Green Hill Solar Farm

Statement of Common Ground: Environment Agency Revision D

Document Reference: EX7/GH8.3.5_D

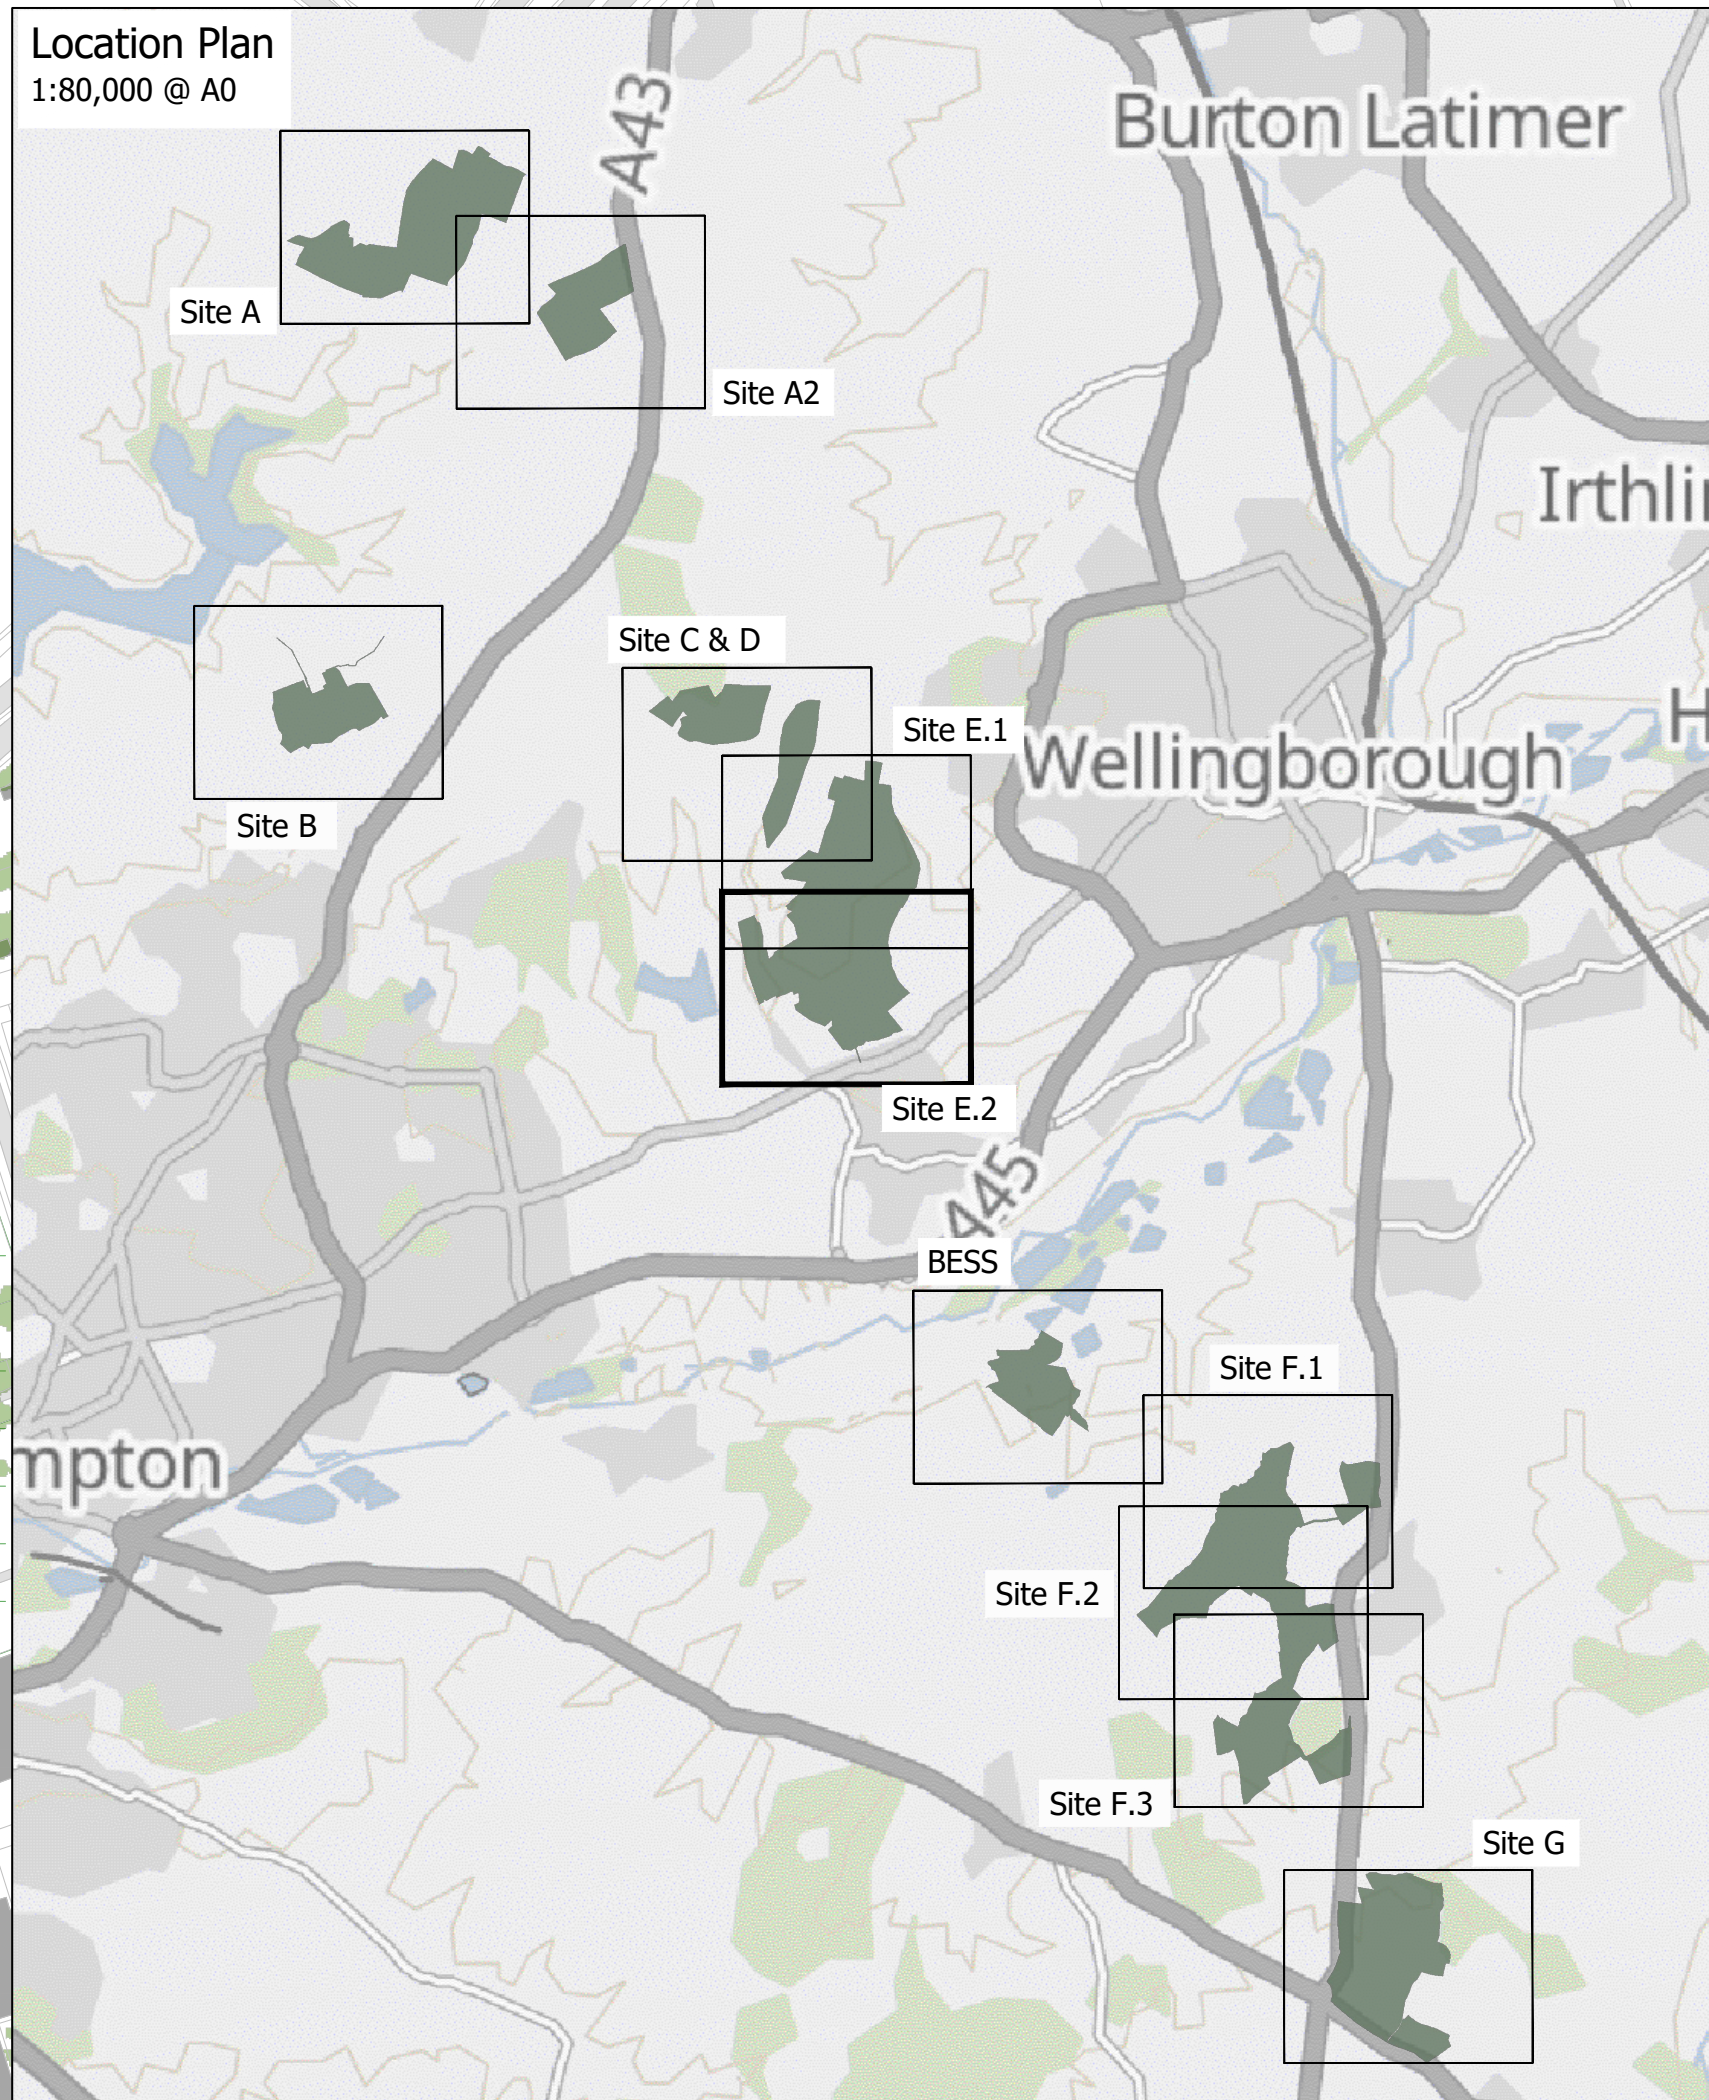
Matter	Details of Matters for Discussion	Applicant Position	Consultee Position	Status
			<p>Green Hill EF29 and EF30 do not include panels and are proposed areas of diverse wildflower meadow as shown on ES Figure 4.15 Landscape and Ecology Mitigation Plan E (Sheet 2) [REP6-027].</p> <p>Panels within Green Hill EF27 been offset from Hockerhill Farm. Based on a review of approximate markup provided by the Environment Agency and Ordnance Survey data, the panels appear to be appropriately offset from the identified spring.</p> <p>If springs were present and contributing to a wet habitat (such as a watercourse or wet grassland), these habitats would have been recorded as such during the habitat walkover surveys. These surveys were completed at various times of year between August 2023 and September 2025 across the Order Limits, and plant communities associated with wet habitats would likely have been present and detectable during</p>	<p>up by impermeable soils and rock.” – Freshwater Habitats Trust [accessed 16/03/26]</p> <p>It is pleasing to see that the headwaters of the watercourses identified in Chapter 10 of the ES will be subject to the suggested buffers included in the protection framework.</p> <p>Consultee Position following Applicant Response 30/03/2026</p> <p>Following further clarification from the Applicant, this matter is resolved and can be agreed.</p>
